**WEST SUSSEX COUNTY COUNCIL
STRATEGIC PLANNING CONSULTATION**

SUBJECT: AL/105/12-Erection of building for lorry storage and plant & machinery workshop on existing hardstanding - This application is a Departure of the Development Plan.

Greater Glebe, Brittens Lane, Fontwell, Eastergate, West Sussex, BN18 0ST

Proposed Site Plan @ 1:500
Ordnance Survey, (c) Crown Copyright 2012. All rights reserved. Licence number 10002044920449

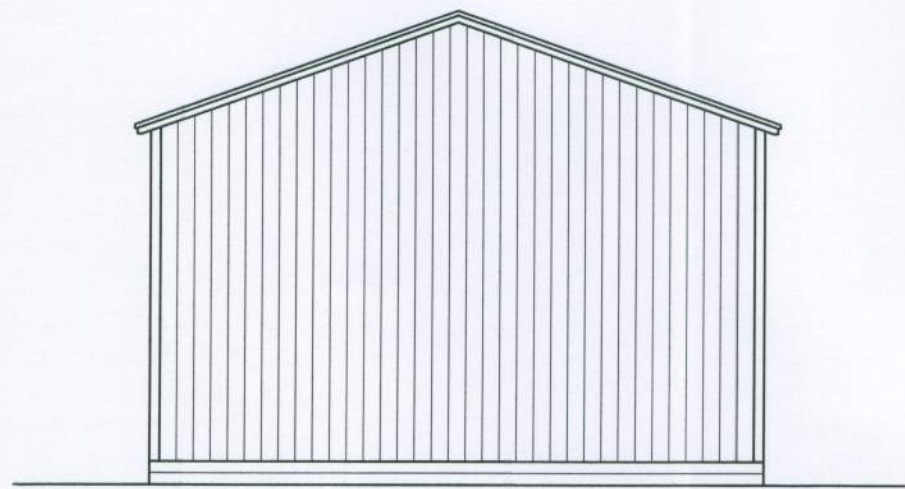
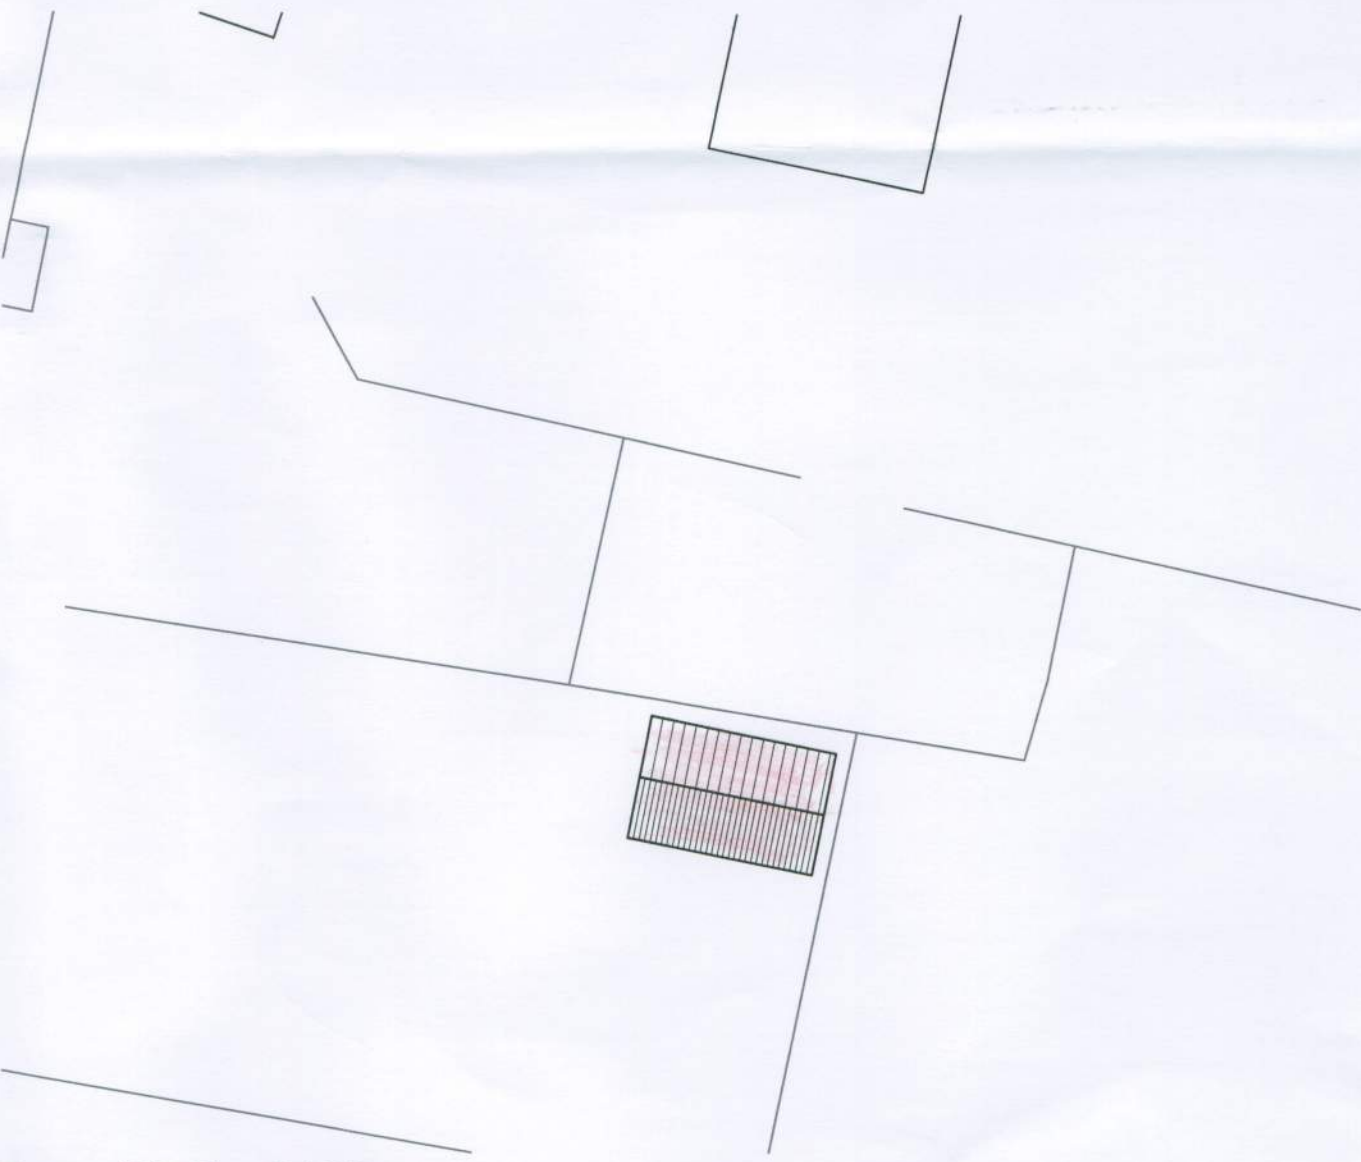
There are no changes proposed to the existing access to the site. Visibility appears acceptable from an inspection of the plans. With consideration for the operation of the site, the additional provision to store lorries would not be considered overprovision at this time. Further consideration would be needed if the business was to grow further and additional spaces are needed or the operation of the parking over spilling into Brittens Lane.

Therefore, the Highway Authority has no concerns with this proposal.
